# CITY OF ALBUQUERQUE

**RE: 3601 Seven Bar Loop Rd NW**  
**Grading and Drainage Plan**  
**Engineer's Stamp Date: 02/26/2026**  
**Hydrology File: B14D019**  
**Case # HYDR-2026-00074**

Based upon the information provided in your submittal received 02/27/2026, the Grading and Drainage Plan **is not approved** for Grading Permit and Building Permit. The following comments need to be addressed for approval of the above referenced project.

| TIERRA WEST, LLC 5571 MIDWAY PARK PLACE NE ALBUQUERQUE, NM 87109 (505) 858-3100 www.tierrawestllc.com | 2024014-GRE | SHEET # GR-1 |

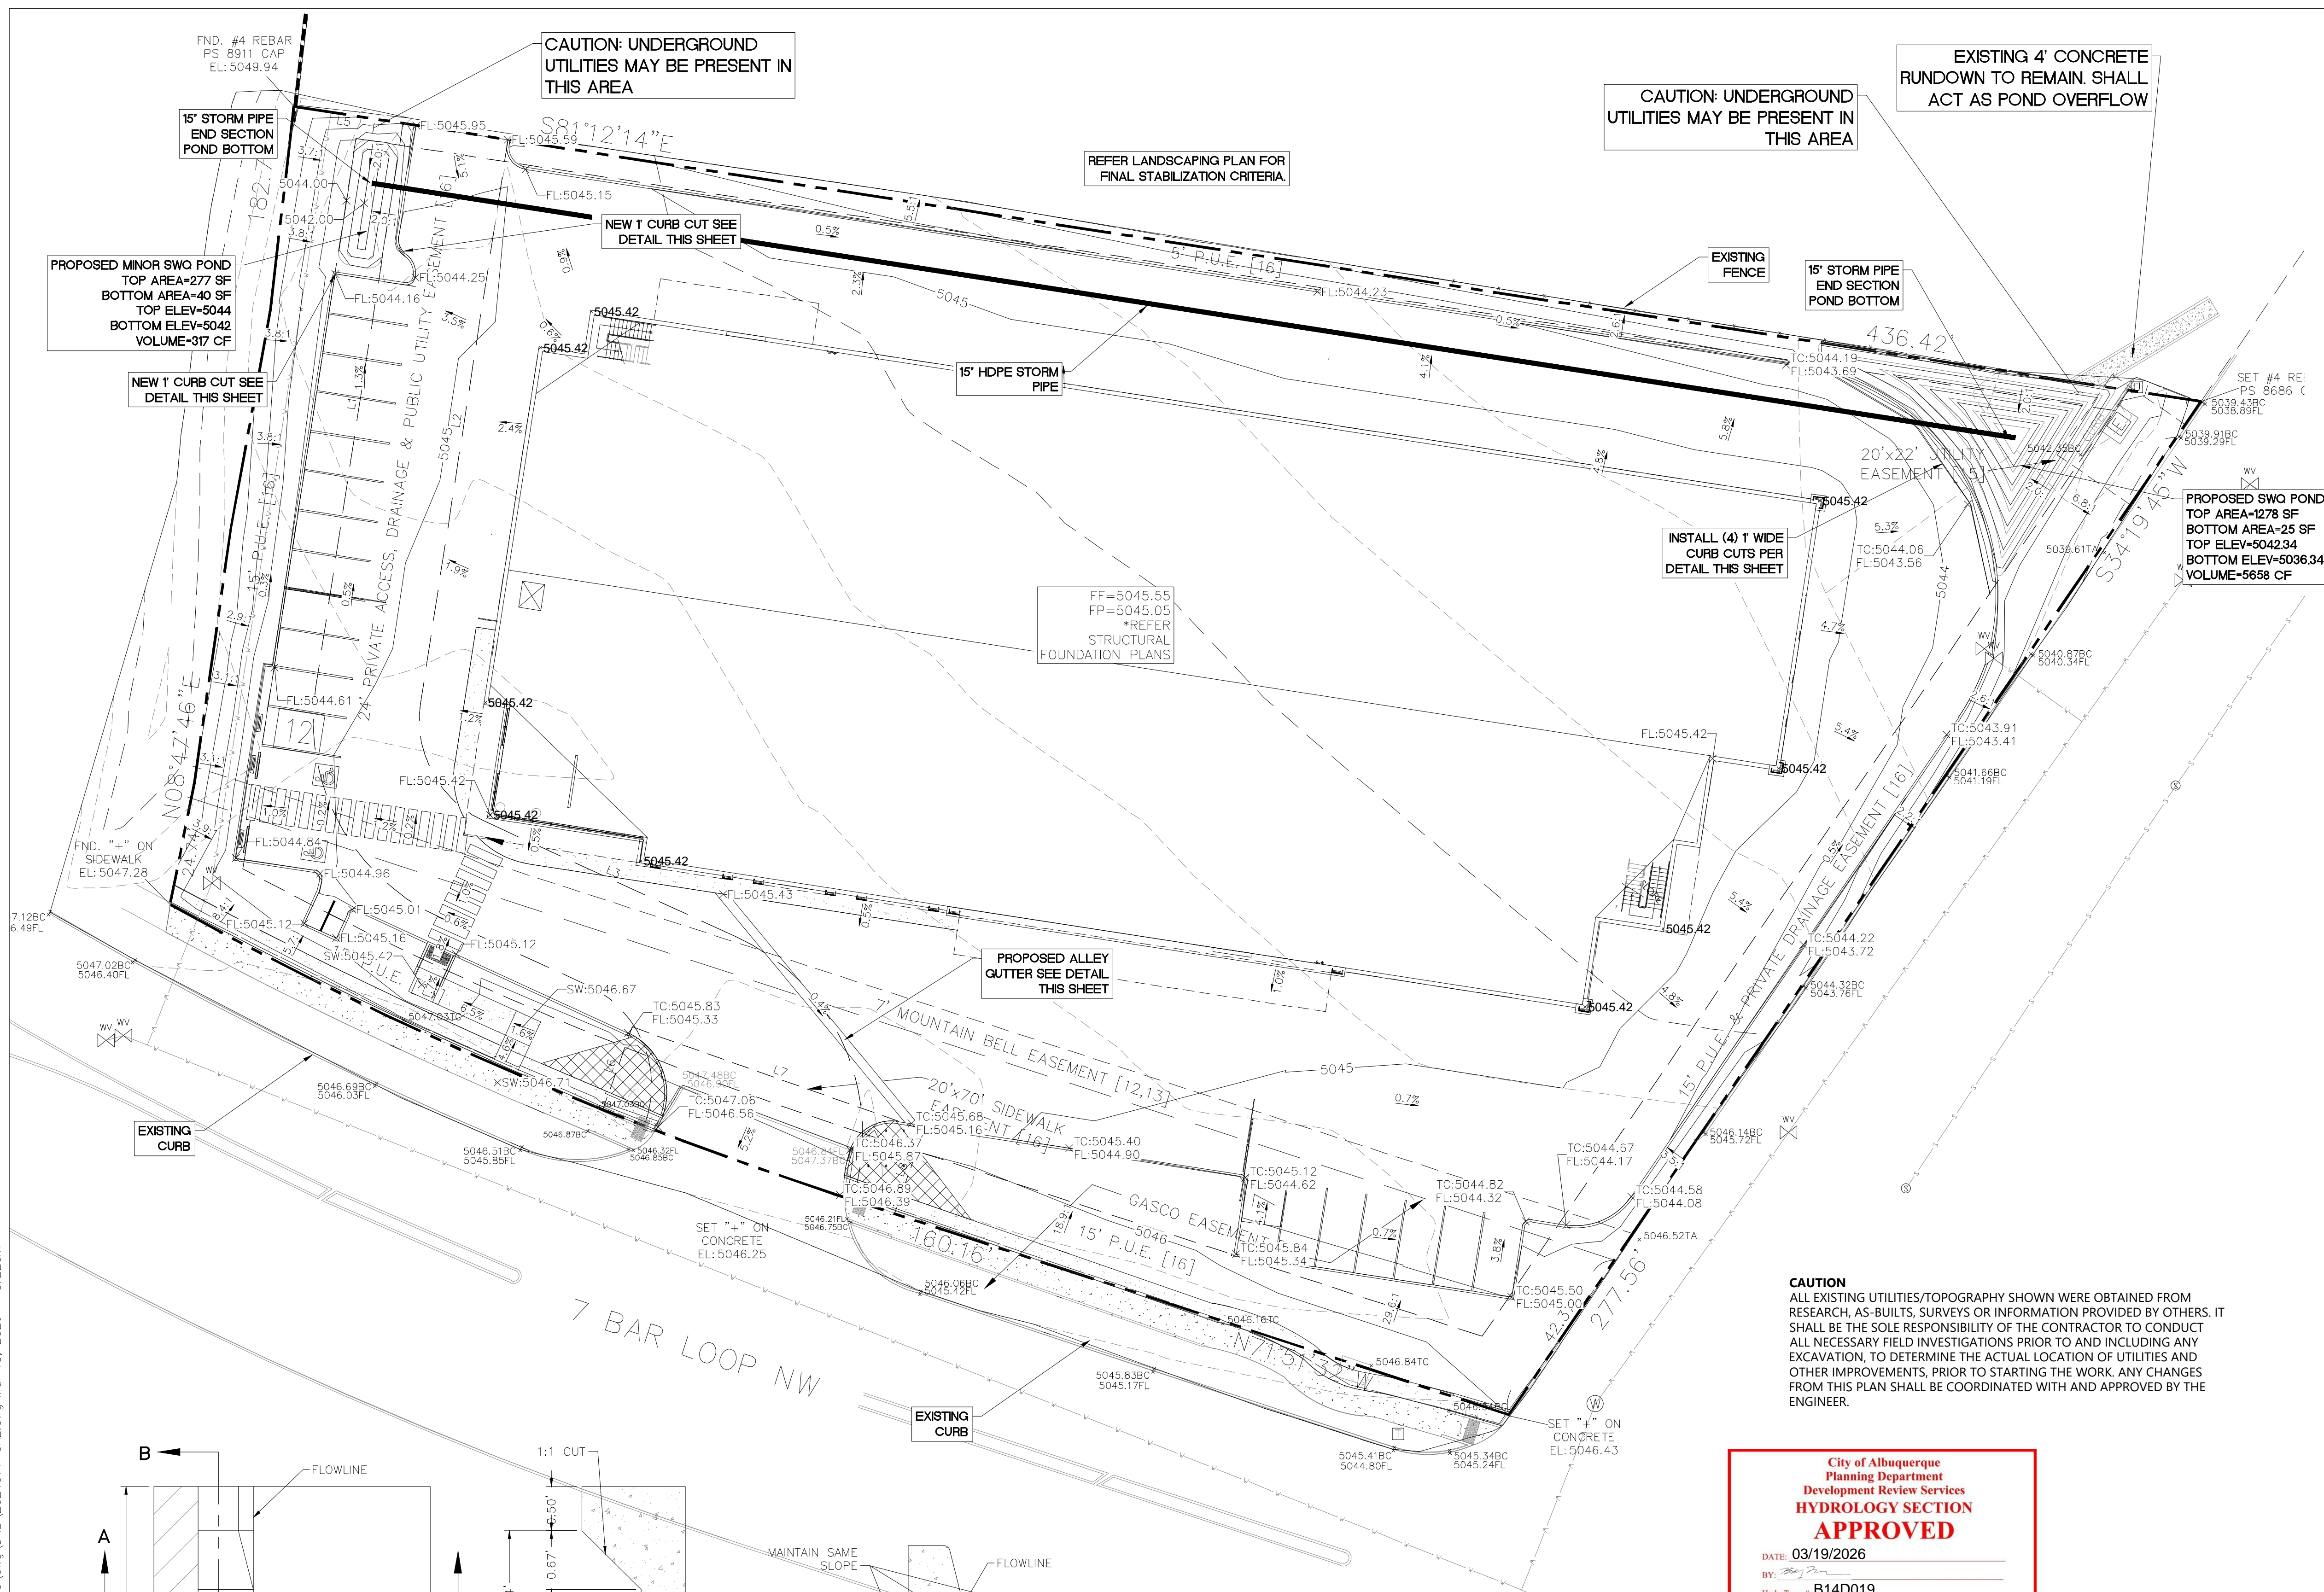
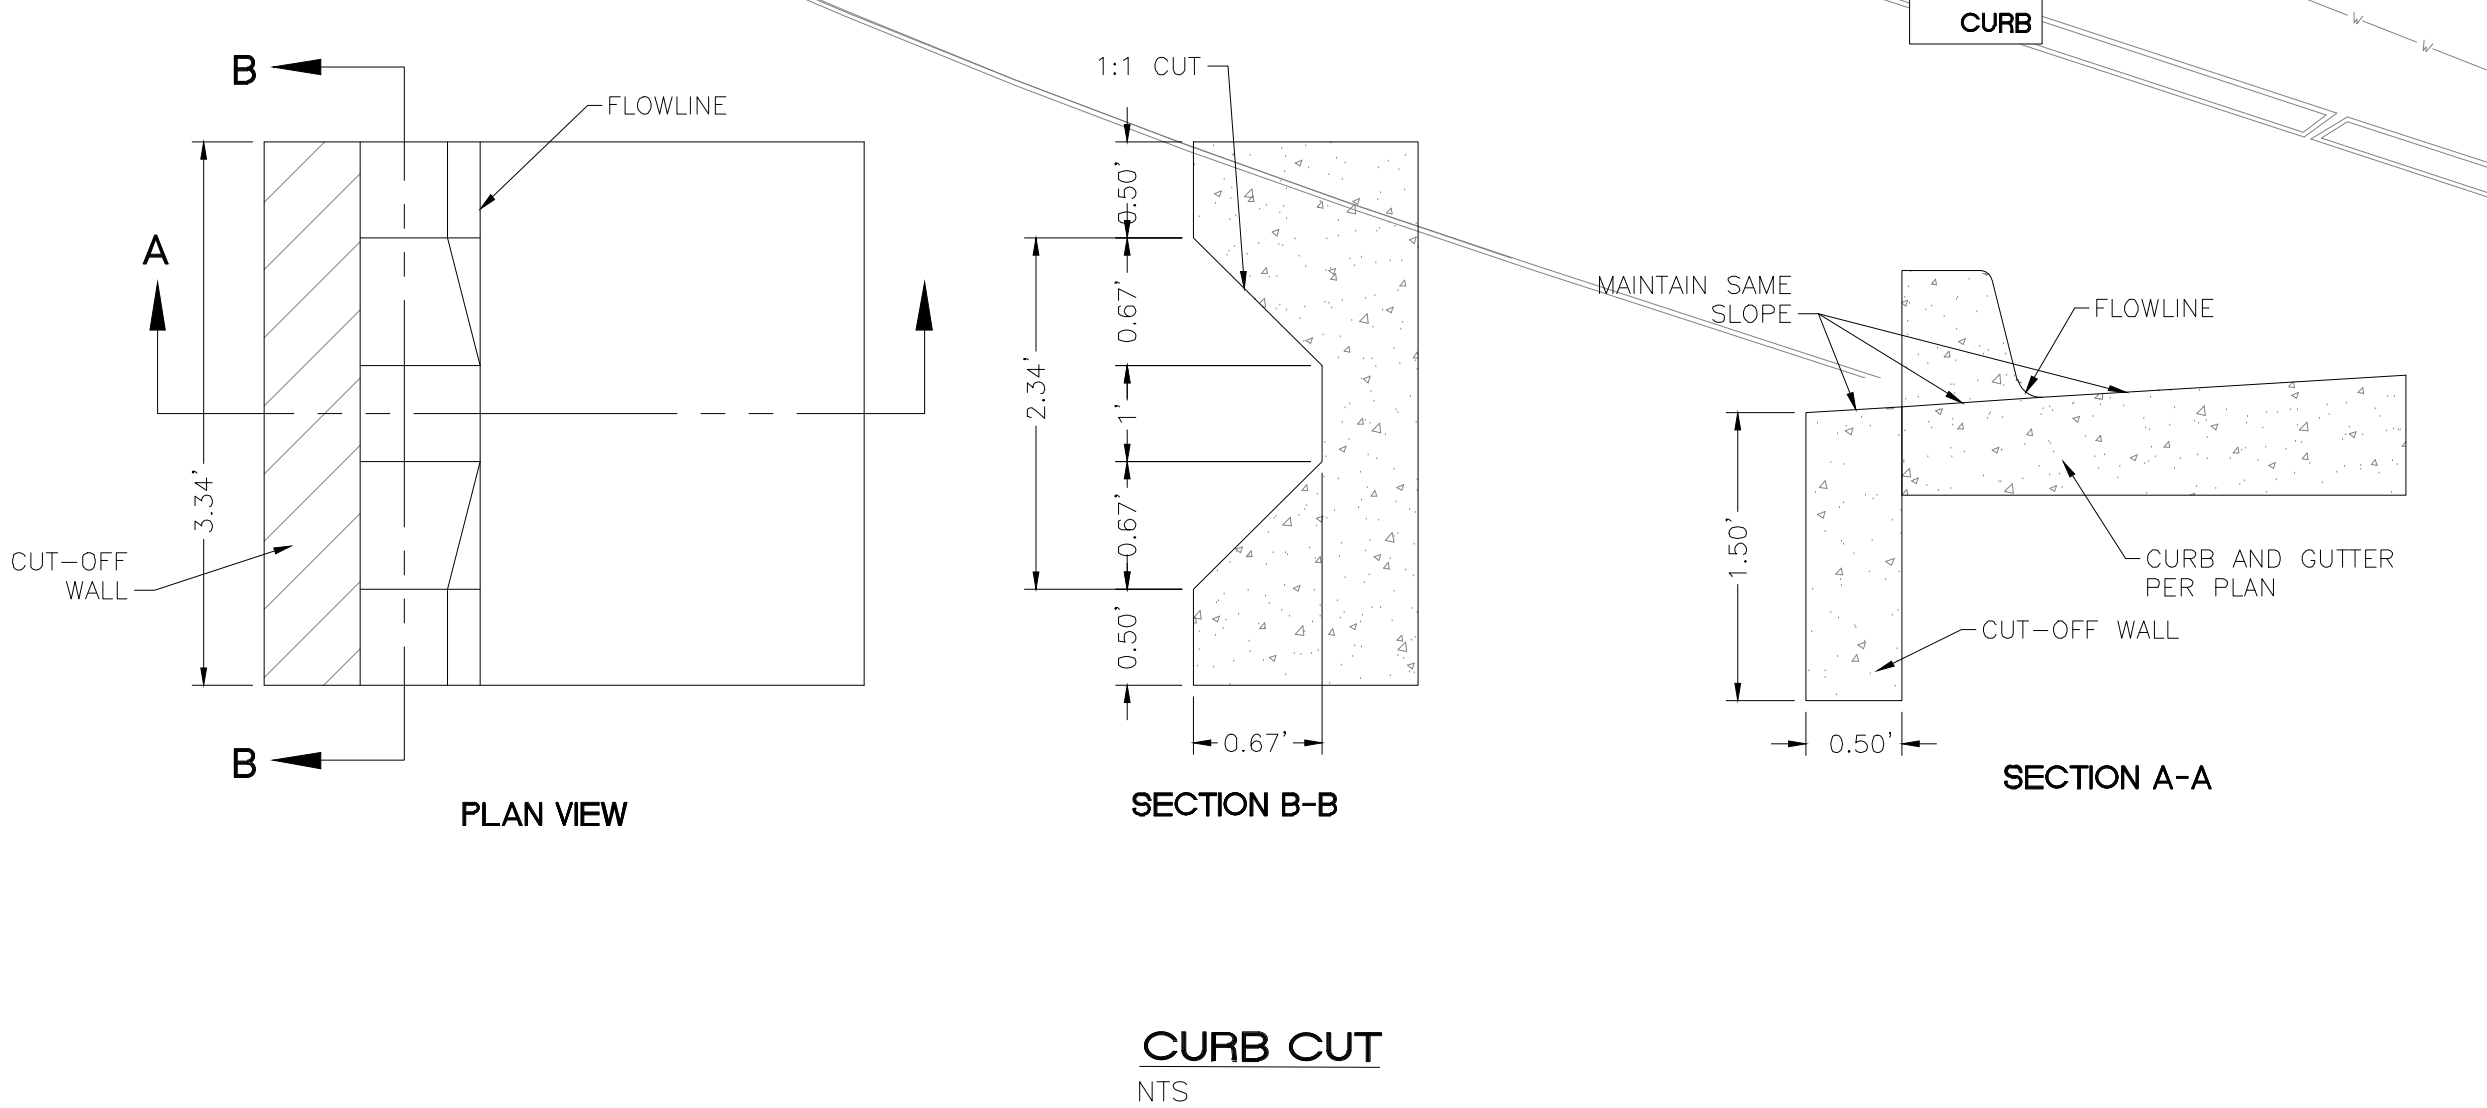
1. Please provide the legal description of the property.
2. Please provide the Benchmark information (location, description and elevation) for the survey contour information provided.
3. Show finished floor and finished pad elevations for all structures.
4. Please make sure treatment areas add up to 100%
